**Consultation Response from KC,
Trees**
2026/90938 land at, Hanging Stone Road, Berry Brow, Huddersfield, HD4 7QU
Erection of detached dwelling (within the curtilage of a Listed Building)
Date Responded: 15/07/2026
Responding Officer: JD
Responding Ref: HU1/74
1. T1, G15, T17, T18 and T20 categorisation

Proposed Planting Plan

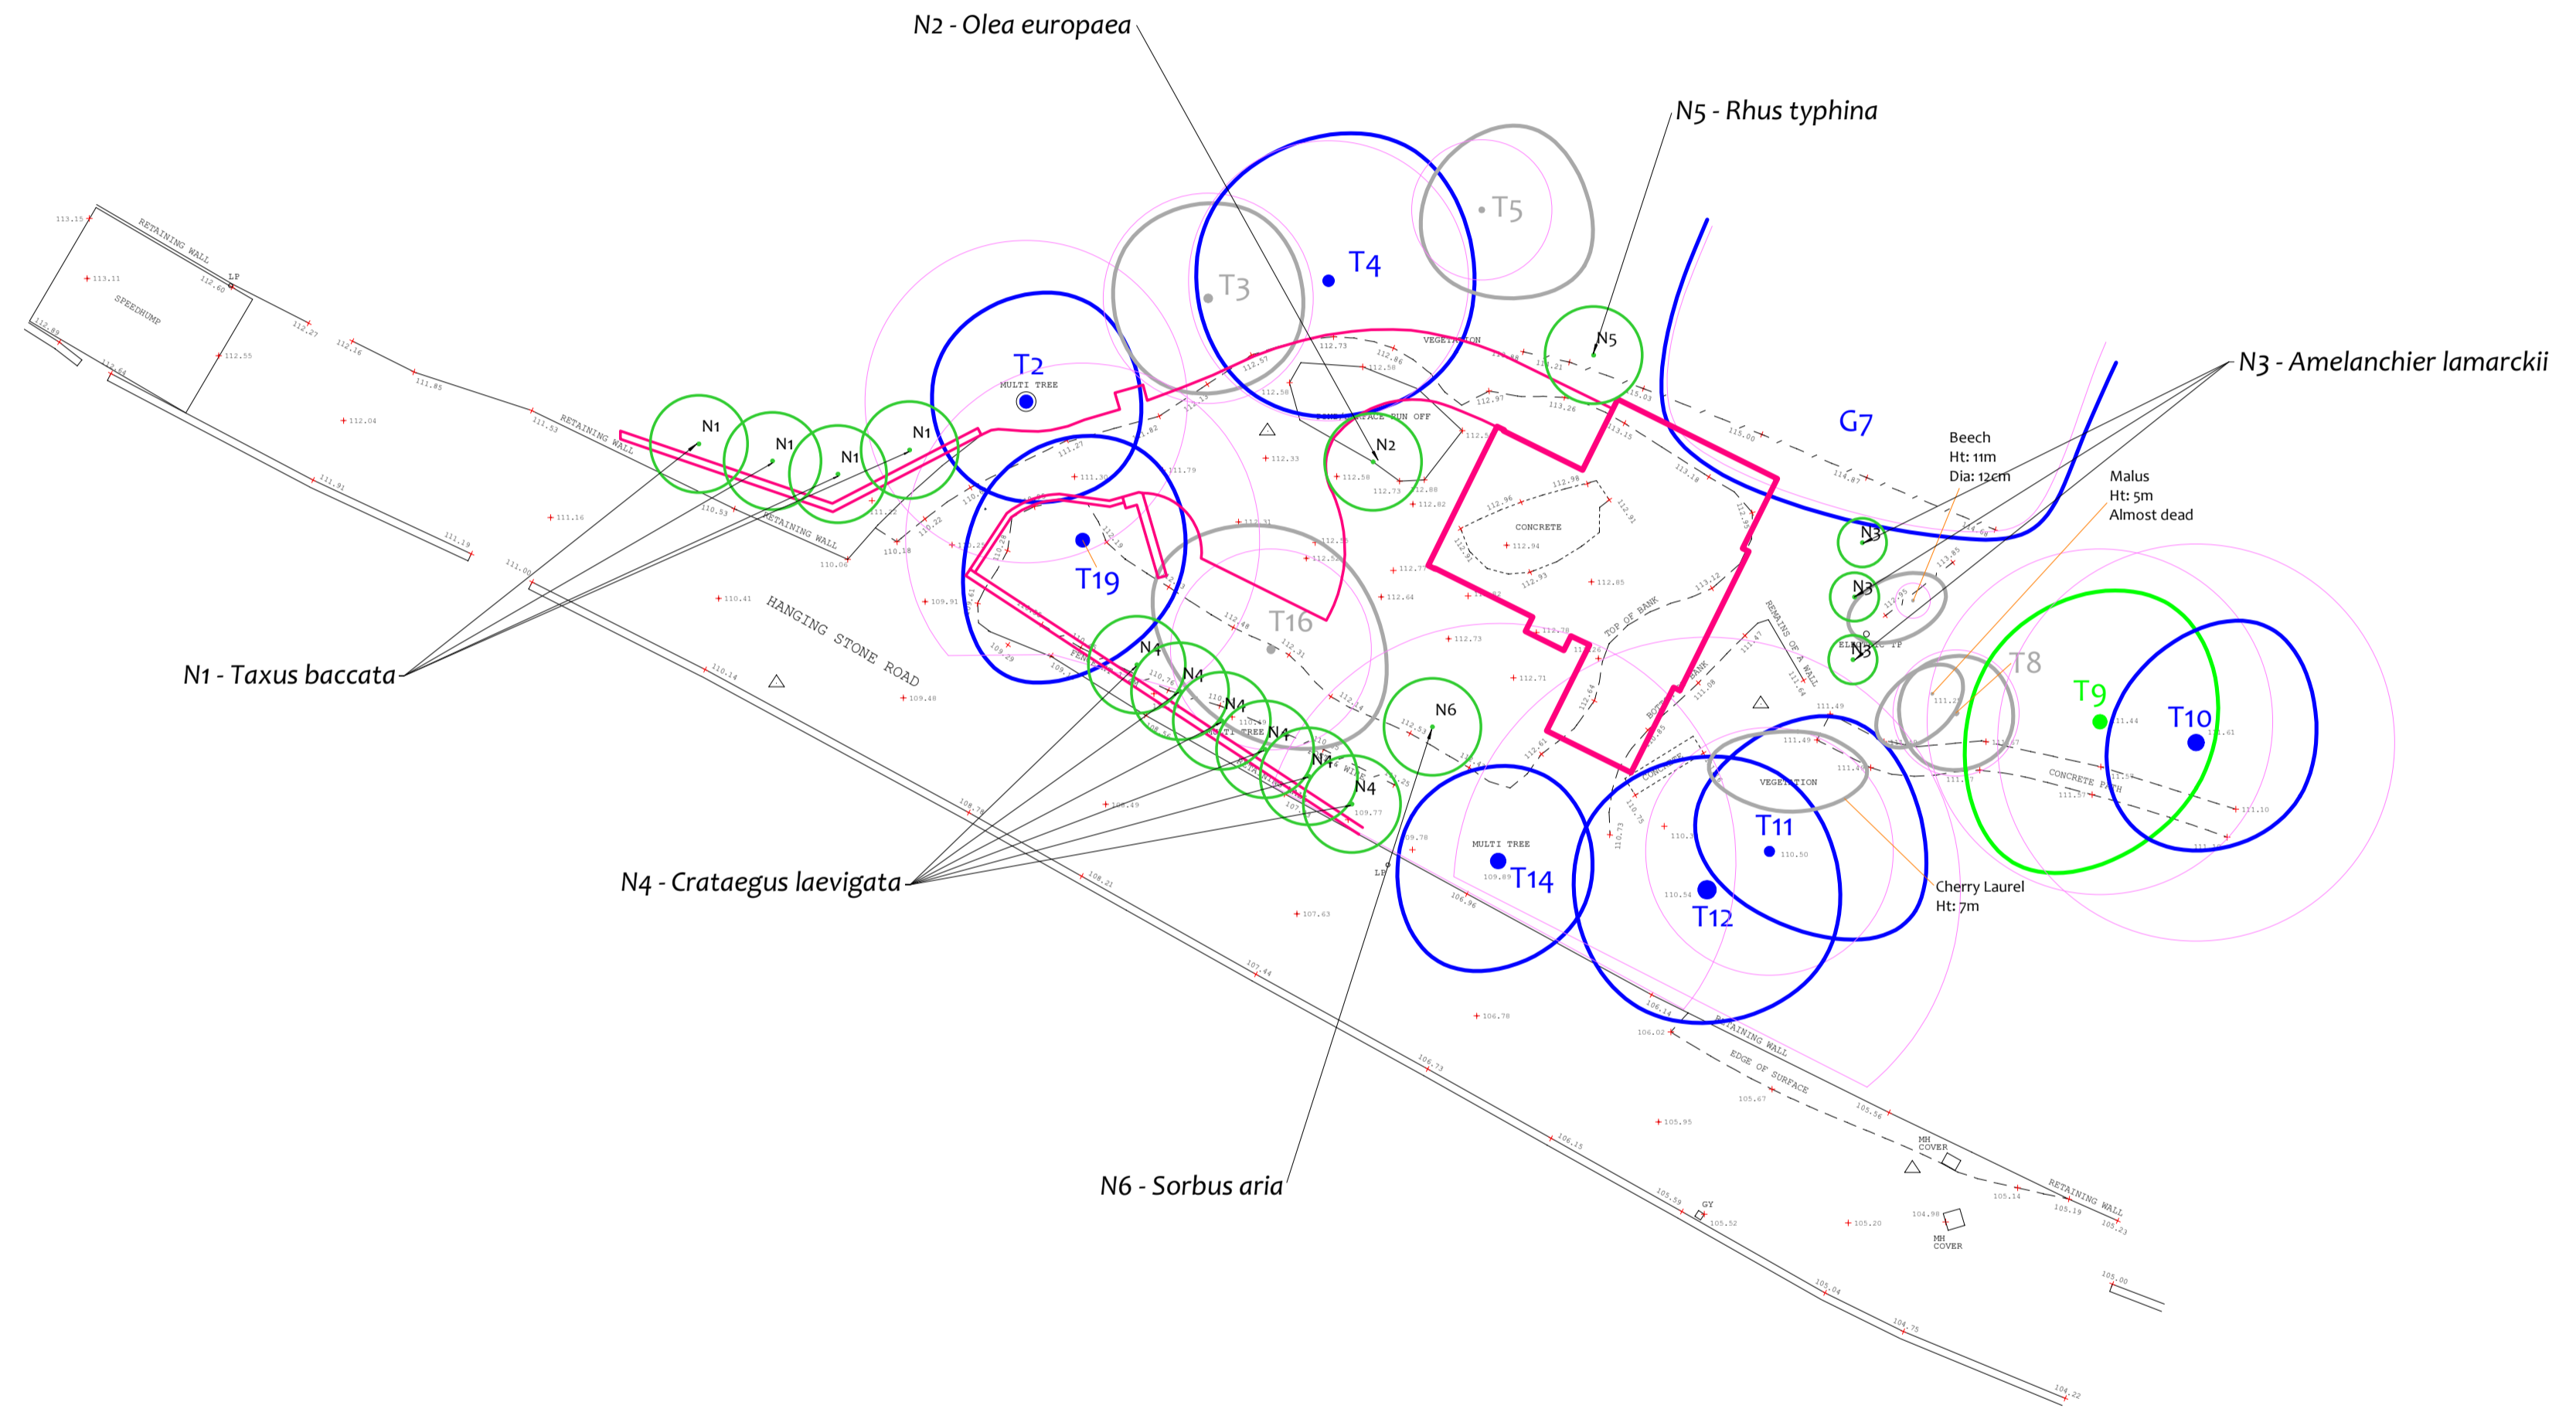
Whilst the comments from '18.05.2026 Arboriculturist response' are noted and valid KC trees view category C trees as potential trees for removal to facilitate development. In this instance taken on an individual basis the trees may be categorised as C trees however as a group they provide a greater amount of amenity value due to their location screening the site from Hanging Stone Road and as part of the wider woodland. They also sit opposite a designated Ancient & Semi-Natural Woodland and could be considered part of this prior to Hanging Stone Road being constructed which adds more weight to the trees value. Therefore, the KC trees would still object to their removal to facilitate the development.

Again comments from '18.05.2026 Arboriculturist response' are noted and valid however even with the removal of any retaining walls and the implementation of a permeable surface and cellular confinement system there is still likely to be an impact, even if it is less, on the immediately adjacent trees, most notably T2, T4, T16 and T19. Therefore KC trees still objects on these grounds.

Although maintenance and clearance of gutters should be easy to manage KC trees still receives many applications each year to have TPO trees removed relating to these issues. Due to the orangeries position being north of the Category B trees, even with alterations reducing its footprint, the shade cast on this room will be significant for most of the year. There is also likely to be naturally occurring deadwood which drops from the trees (specifically T12) in high winds which poses a hazard to the mostly glass room. Again KC trees would object due to these factors rendering the room virtually uninhabitable and leading to pressure for tree works.
